# Screening for Environmental Impact Assessment

**Section 146B Alteration Request (ABP PA92.319013)**

## **Medite DAC Europe**

Redmondstown, Clonmel, County Tipperary

C

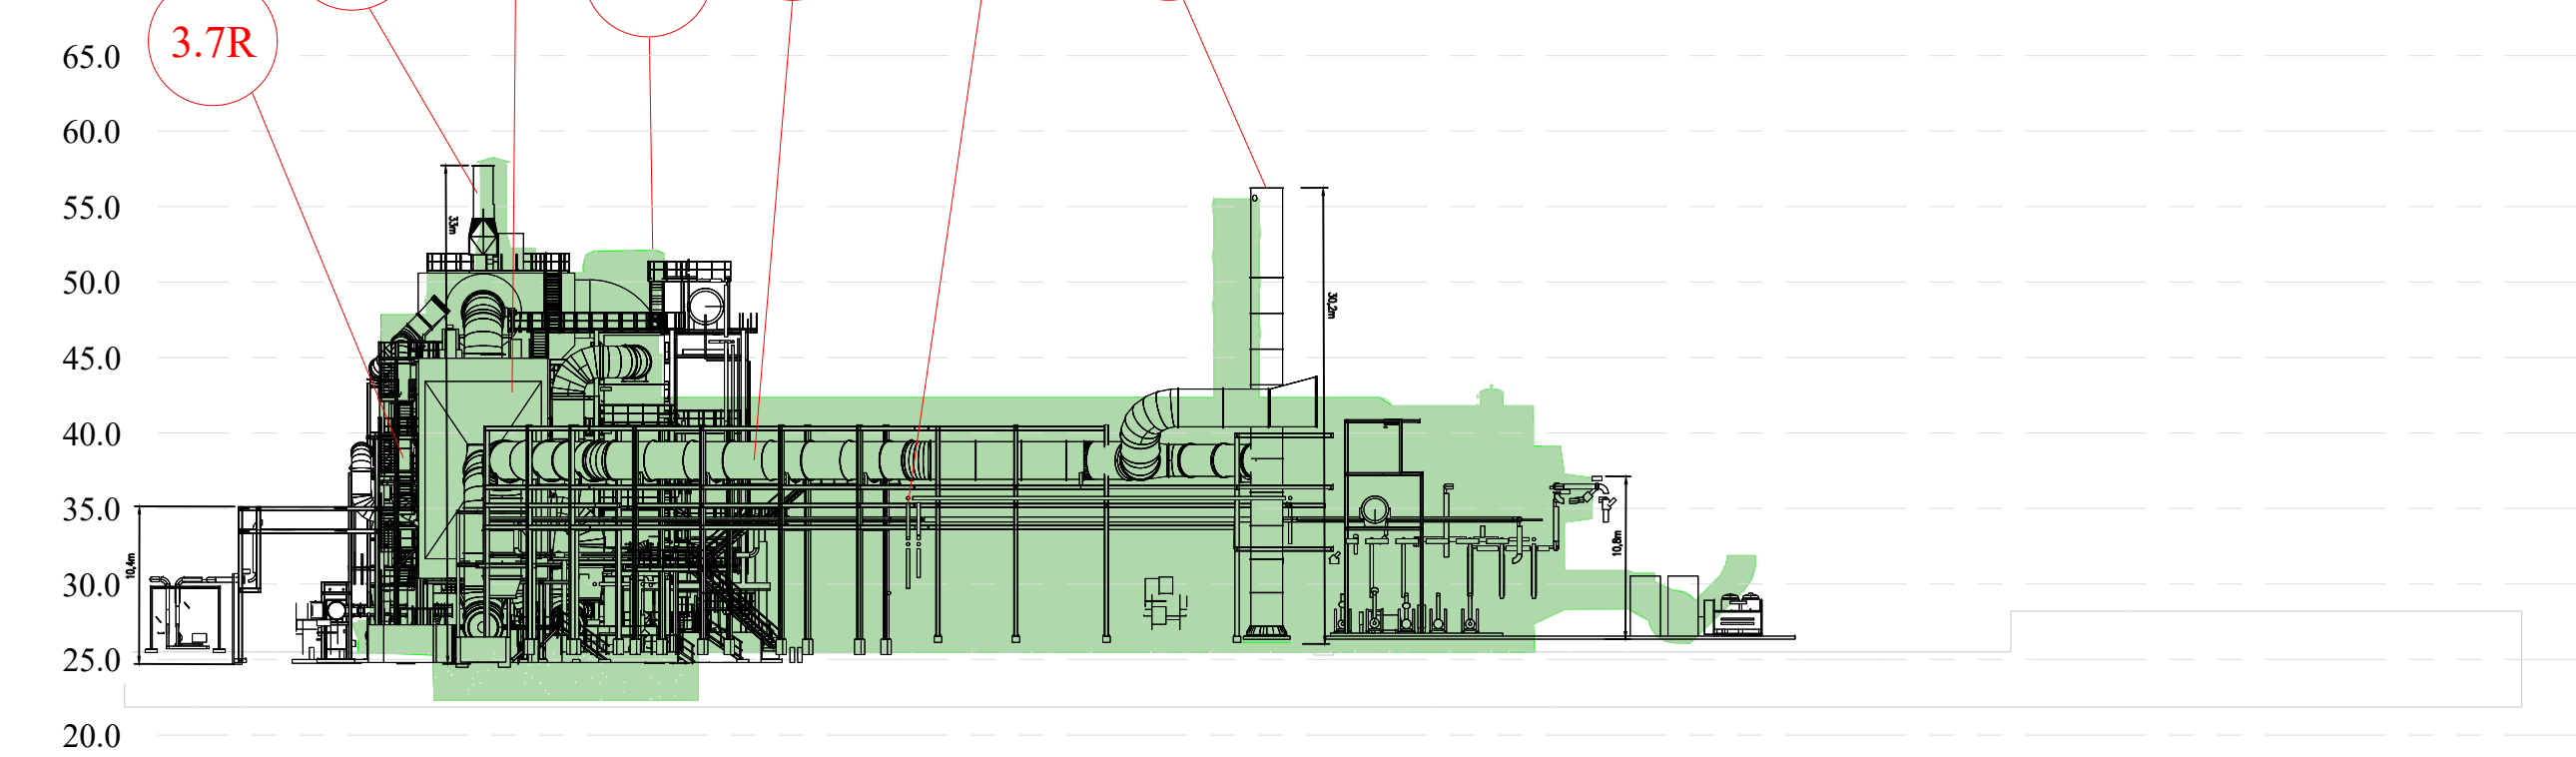
No.	Permitted Item	Description	No. (R)	Proposed Alteration Dimensions	Summary of Alterations
ITEM 3.1	Line 1 Wet Fuel Metering Bin (18.6m x 15.7m x 4.5mH) Area = <del>254.5</del> <sup>5</sup> 292.0m <sup>2</sup>	The wet fuel (bark or chips) is received by the Wet Fuel Metering Bin from the conveying systems referred to in Development Area 1.	ITEM 3.1R	Line 1 Wet Fuel Metering Bin 28.8m 7.4m x 10.3mH  Difference in dimensions: +10.2m x -8.3m x +5.8m H	<b>Proposed Area:</b> 213.1m <sup>2</sup>  <b>Area difference:</b> a reduction of -78.9m <sup>2</sup>  Resized & relocated to match operational requirements

ITEM 3.2	Line 1 Energy System Fuel Feed Conveyor (33.2m L x 1.1m W conveyor Max Height 17.8m Area = 38.0m <sup>2</sup>	The Wet Fuel will be discharged from the Wet Fuel Metering Bin to a Line 1 Wet Fuel Metering Bin Outfeed Weight Belt and a Line 1 Energy System Fuel Feed Conveyor to the Grate Furnace Combustion Chamber with the energy plant.	ITEM 3.2R	Line 1 Energy System Fuel Feed Conveyor 31.4m L x 1.0m W conveyor Max Height 20.7m Difference in dimensions: -1.8m L x -0.1m x +2.9m H	<b>Proposed Area:</b> 31.4m <sup>2</sup>  <b>Area difference:</b> a slight reduction of -6.6m <sup>2</sup>  Adjusted to accommodate metering bin and energy plant  <b>Height increase:</b> +5.8m giving a total height of 10.3m.

No.	Permitted Item	Description	No. (R)	Proposed Alteration Dimensions	Summary of Alterations
	32.5m x 21.6m x 33m Area = <del>442m<sup>2</sup></del> <sup>6</sup> 702m <sup>2</sup>	Inside the TFH, the Wet Fuel will combust together with fresh air provided by the Primary Fan and Secondary Fan inside the Combustion Chamber to produce hot flue gas. An emergency stack on the TFH with a damper will automatically open upon upset conditions. The hot flue gas will supply heat to a thermal fluid that is piped through the energy plant, which in turn provides heat to the Line 1 press and a Steam Generator).		28.2m x 21.0m x 33mH: Stack Height  Difference in dimensions: -4.3m x -0.6m x 0mH	<b>Area difference:</b> a reduction of -109.8m <sup>2</sup>  Reduced size & minor re-location moved by 11.8m west to accommodate equipment

ITEM 3.4	Line 1 Dry Electrostatic Precipitator (within the TFH dims of 27.6m x 13.7m x 23.3mH ) Area = 286.9 m <sup>2</sup>	The Fly Ash inside the Hot Gas will be cleaned and captured by a Dry Electrostatic Precipitator (Dry ESP) and discharged through the SSC Rotary Airlock onto the Wet Ash Conveyor. The Bottom Ash will be discharged through the holes on the grate and recovered by the Wet Ash Conveyor to the Ash Storage Bunker for disposal.	ITEM 3.4R	Line 1 Dry Electrostatic Precipitator (within the TFH dims of 24.5m x 11.1m x 23.3.0mH  Difference in dimensions: -3.1m x -2.6m x 0mH	<b>Proposed Area:</b> 271.9m <sup>2</sup> <b>Area difference:</b> a slight reduction of -15.0m <sup>2</sup>  Resized & Location moved to accommodate equipment

ITEM 3.5	Line 1 Hot Gas Duct 105m long x Ø3.2m Area = 336.0m <sup>2</sup>	The Hot Gas will be transported to the Line 1 Dryer Systems (Core and Face dryers) via the Hot Gas Duct where it will be mixed with ambient air for the purpose of drying the wet wood fibre. The existing mixing chambers located within the Line 1 Dryer Building will be modified to accommodate the new hot gas duct.	ITEM 3.5R	Line 1 Hot Gas Duct 98.1m long x Ø2.6m Difference in dimensions: -6.9m x Ø-0.6m	<b>Proposed Area:</b> 255.0m <sup>2</sup> <b>Area difference:</b> a reduction of -81.0m <sup>2</sup>

ITEM 3.6	Line 1 Start Up Stack (30.2mH x Ø3.6m)	The Hot Gas duct will contain an abort gate & Start-up Stack. This Abort Gate and start-up stack serves as a by-pass of the Hot Gas Flow	ITEM 3.6R	Line 1 Start Up Stack 30.2mH x Ø2.7m	<b>Proposed Area:</b> 9.0m <sup>2</sup>

No.	Permitted Item	Description	No. (R)	Proposed Alteration Dimensions	Summary of Alterations
	Area = 10.8m <sup>2</sup>	to the dryer to atmosphere in case the dryer system is in upset conditions or during plant start-up.		Difference in dimensions: 0mH x -0.9m	<b>Area difference:</b> a slight reduction of -1.8m <sup>2</sup> Moved due to constructability constraints 30.2 m height is maintained and relocated by 10.3m east.

ITEM 3.7	Line 1 Sander Dust Silo (Ø 6.0m x 16mH) Area = 28.3m <sup>2</sup>	As referenced in 'Pneumatic (Dry Fuel) Systems' in Development Area 1, the existing extraction systems are to be modified and will a proposed Sander Dust Silo Ø 6.0m x 16mH and associated filter plant, located adjacent to the proposed Line 1 Energy Plant. The Sander Dust Silo will discharge material into the Line 1 Energy Plant as fuel.	ITEM 3.7R	Line 1 Sander Dust Silo (Ø 3.0m x 13.3mH) Difference in dimensions: 0m	Proposed Area: 9.0m <sup>2</sup> <b>Area difference:</b> reduction of -19.3m <sup>2</sup> Incorporated into the frame structure of the to energy plant

ITEM 3.8	Line 1 Thermal Fluid Piping 217m L x Ø 0.6m x 16.3mH Area = <del>40.9</del> 130.2 m <sup>2</sup>	The Thermal Fluid Piping will transport the heated thermal fluid to and from the energy plant and both the existing Line 1 Press and a new steam generator.	ITEM 3.8R	Line 1 Thermal Fluid Piping 107.1m L x Ø 0.3m x 10.3mH Difference in dimensions: -109.9m x Ø-0.3m	<b>Proposed Area:</b> 32.1 m <sup>2</sup> <b>Area difference:</b> a reduction of -98.1 m <sup>2</sup>

ITEM 3.9	Line 1 Steam Generator 14.4m x 3.5m x 17.9mH Area = 47.5m <sup>2</sup>	The Steam generator will use heated thermal fluid to generate steam for the various existing steam users on Line 1. The new steam piping will connect the steam generator to the existing steam pipe infrastructure.	ITEM 3.9R	Line 1 Steam Generator 13.5m x 4.4m x 10.8mH Difference in dimensions: -0.9m x +0.9m x -7.1mH Reduction of external works as re-located inside existing building.	<b>Proposed Area:</b> 59.4m <sup>2</sup> <b>Area difference:</b> an increase of +11.9m <sup>2</sup> Reduction in height of pipe work

No.	Permitted Item	Description	No. (R)	Proposed Alteration Dimensions	Summary of Alterations
ITEM 3.10	Line 1 Dryer System 34.0m x 17.5m x 13.9mH Area = 505.7m <sup>2</sup>	The Hot Gas generated by the new Line 1 Energy plant will be utilised in the dryer system to dry wood fibre to produce MDF.	ITEM 3.10	Line 1 Dryer System 34.0m x 17.5m x 13.9mH Area = 505.7m <sup>2</sup> As permitted; Inside existing building	No Area Difference
ITEM 3.11	Line 1 Bunded Oil Storage 10.4m x 6.4m x 3.1mH Area = 66.5m <sup>2</sup>	Bunded Oil Storage Tank	ITEM 3.11R	Line 1 Bunded Oil Storage 10.5m x 6.9m x 3.9mH Difference in dimensions: +0.1m x +0.5m x +0.8mH	<b>Proposed Area:</b> 72.5m <sup>2</sup> <b>Area difference:</b> an increase of +6.0m <sup>2</sup>
